Planning Application No: 3/2026/0531

Proposal: Retrospective consent for the erection of an outbuilding, shed and timber boundary fence.

Location: Brathay, 2 Whittam Crescent, Whalley BB7 9SD

STREET SCENE
Scale 1:50

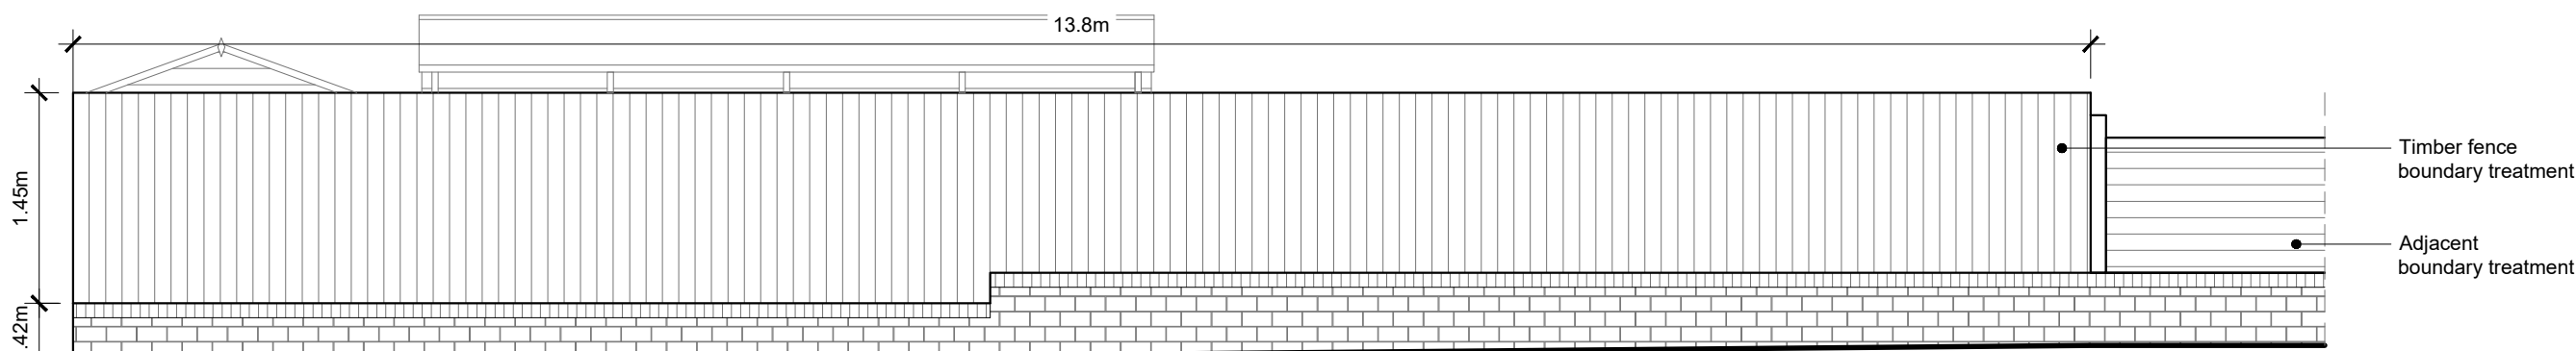
Whilst the erection of the timber boundary fence prevents vehicles exiting from having a clear view to the left this is no worse an arrangement than the previous boundary hedge and vegetation. The highway authority also notes from the Google Street View image in March 2026 that the drive and dropped vehicle crossing have been widened, which can give a visual indication to approaching pedestrians that a vehicle may exit.
